Re: Application Reference 2025/62/92023/W
Land Adjacent to 20b Greenhead Lane, Dalton, HD5 8PP

I write in relation to the above application and further to our letter dated 27th August 2025, to confirm that the Applicants have now issued our clients with formal notice of the application. The notification was dated 25th September 2025 and provides our clients with an additional 21 days to review and comment on the development. We are not aware of the Council undertaking further formal reconsultation, but would assume given the changes to the red line that this will be taking place in advance of determination of the application? Confirmation of the same would therefore be appreciated.

Client			
MISS C HERRERO			
Project			
20C GREENHEAD LANE			
Project No	Drawing No	Rev	
2947	(100)01		
Description			
PROPOSED SITE PLAN			
Scale	Date Drawn	Drawn By	Authorised By
1 : 200 @ A1	MAY 25	HF	JC
Purpose of Issue			
Planning ☒	Building Regs ☐	Tender ☐	Construction ☐
Comment ☐		Info ☐

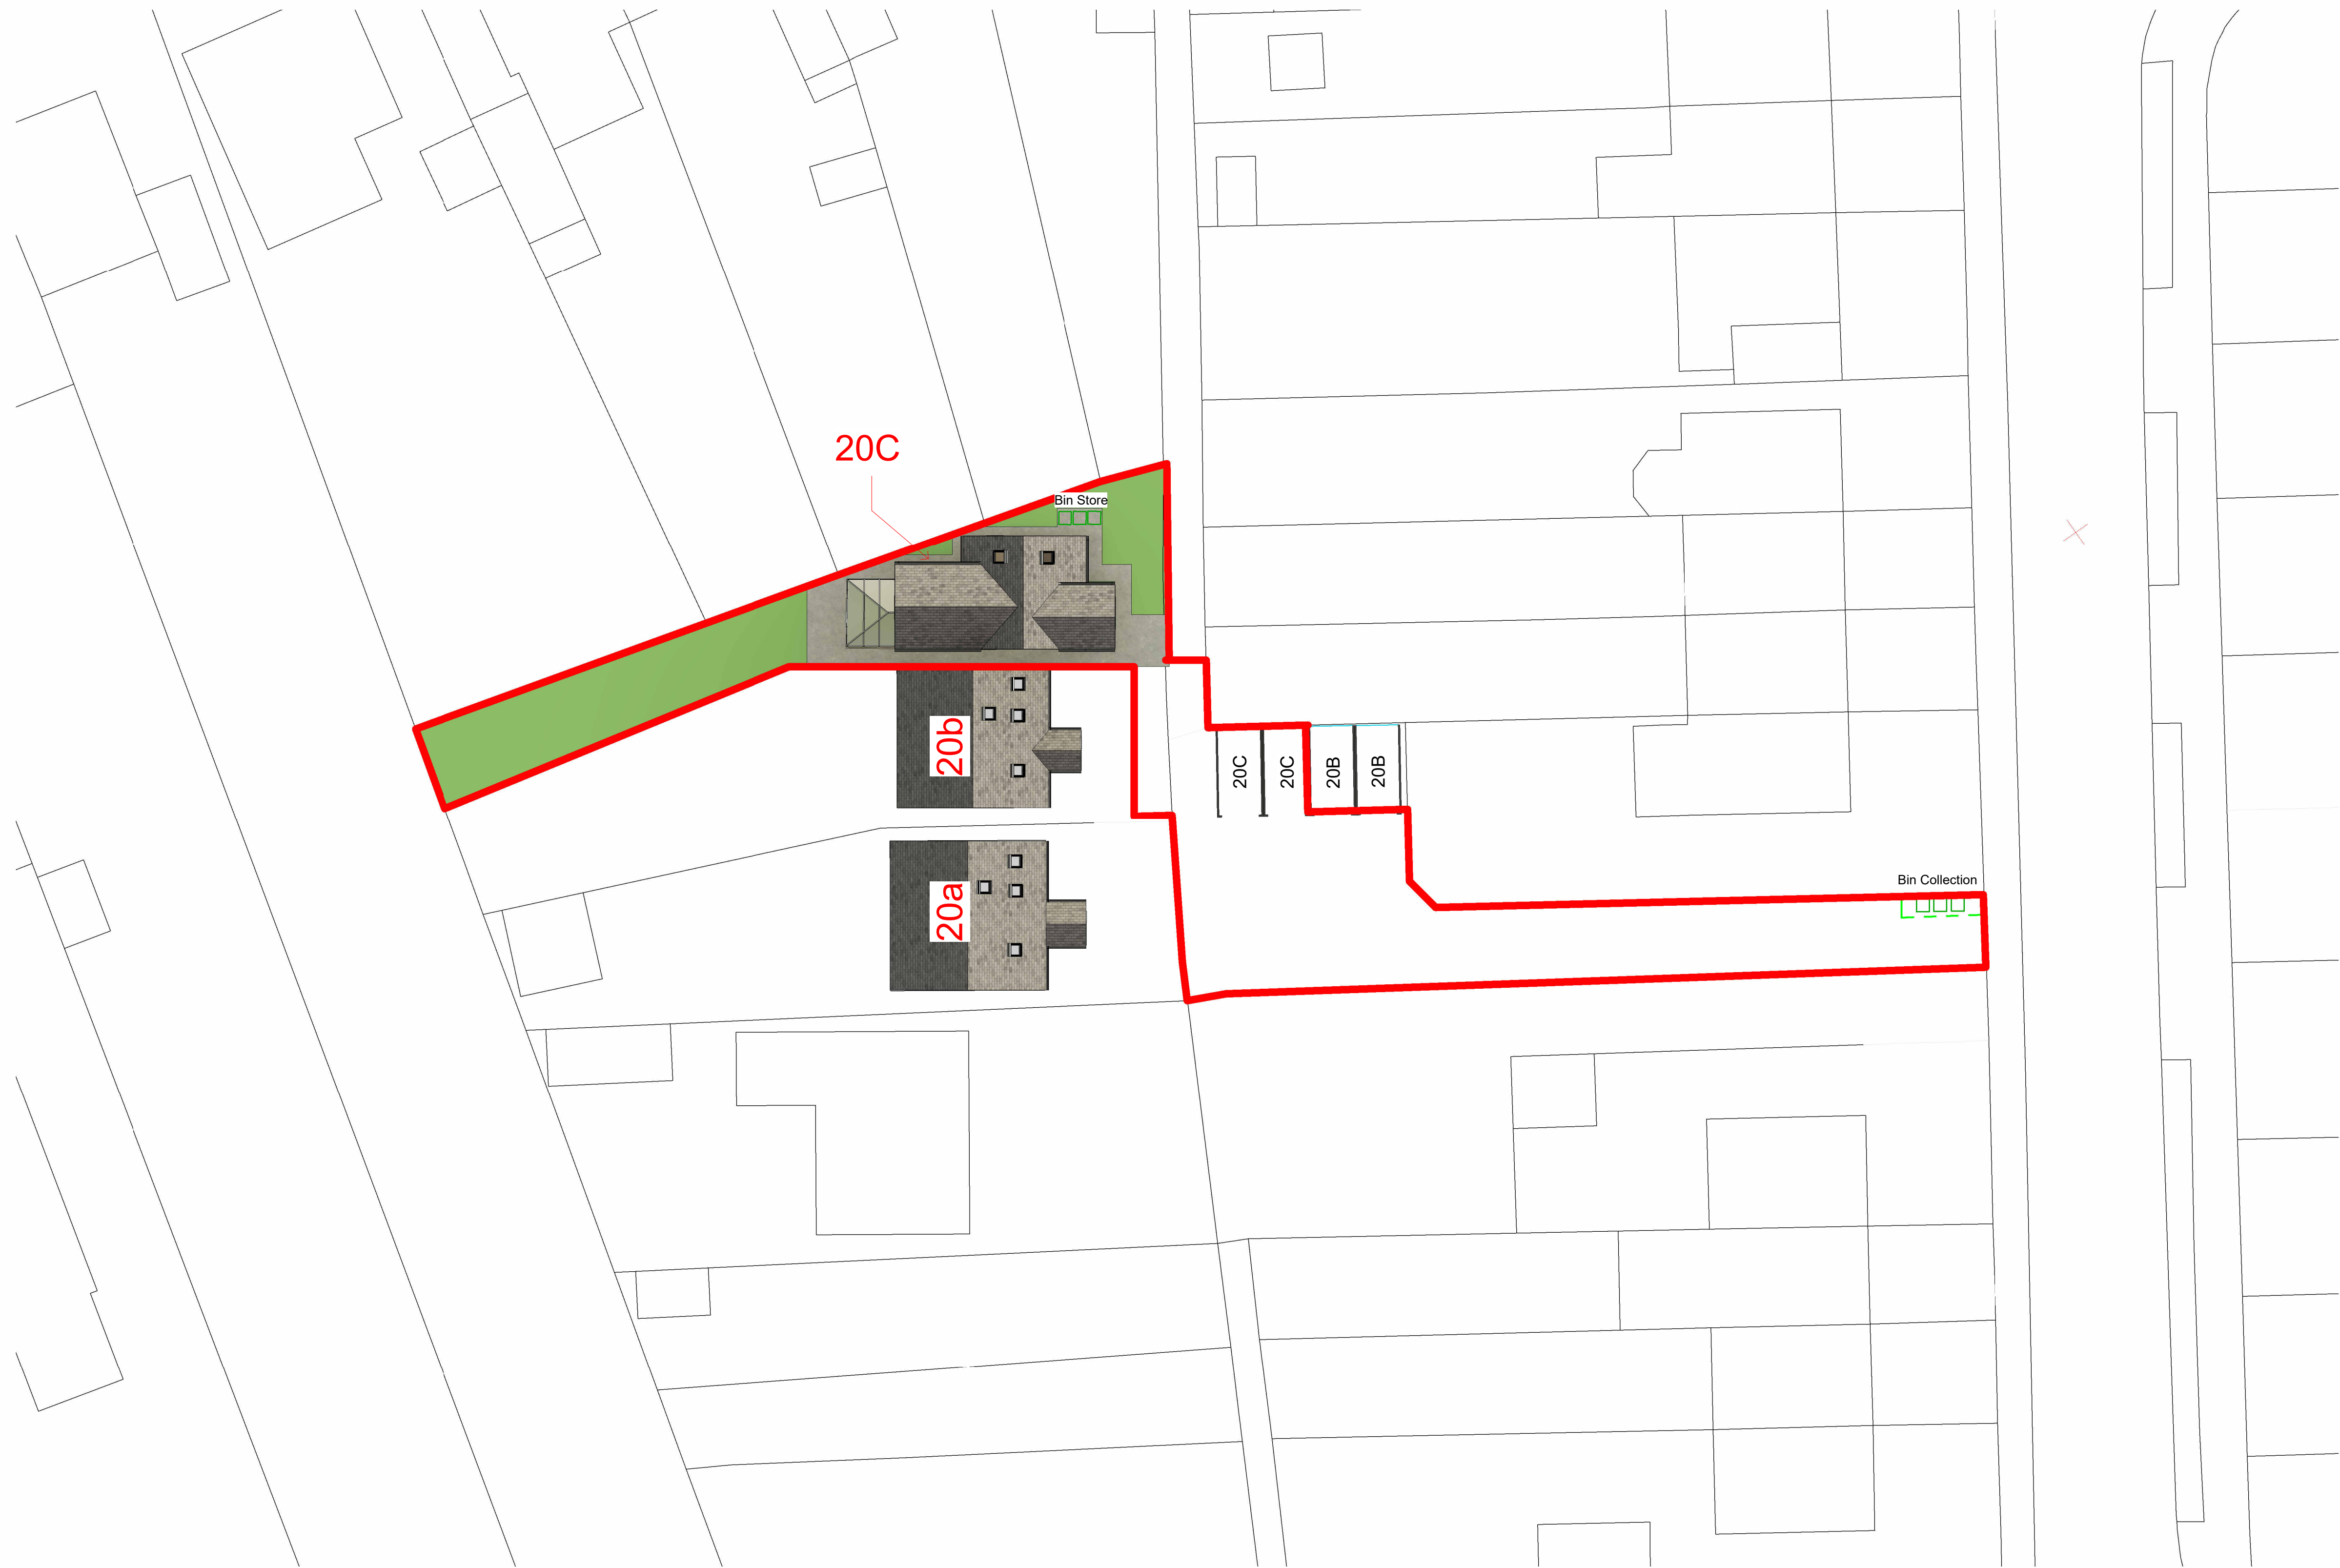
We note that, in addition to serving formal notice on our clients, that the Applicants have also submitted updated plans and a fresh application form. From a review of the new drawings we note that the only change is the correction of the red and blue line and site address, with no other changes being proposed to the scale, form or design of development, Whilst we welcome this correction, we would now query why our clients' property has been included in the application blue line? For clarity, our clients' land and property, other than the access does not form any part of this application and is not under the control of the Applicant.

We are also disappointed that no amendments have been made to the proposed development to seek to overcome some of the concerns set out in original correspondence from August, including in relation to the proximity of the new dwelling to the boundary, loss of privacy and amenity, loss of daylight, overbearing impacts etc. One would have hoped that the need to address the issues on site ownership could well have given the Applicants time to seek to make some revisions to address the comments previously made. For that reason, we must therefore maintain our clients' robust objection to this application, which they deem will have a detrimental impact on their amenity and quality of life in

Its current form. In addition, given the scale and footprint of development proposed, we continue to deem the scheme to represent overdevelopment of the plot and associated resultant harms to the visual amenities of the street scene.
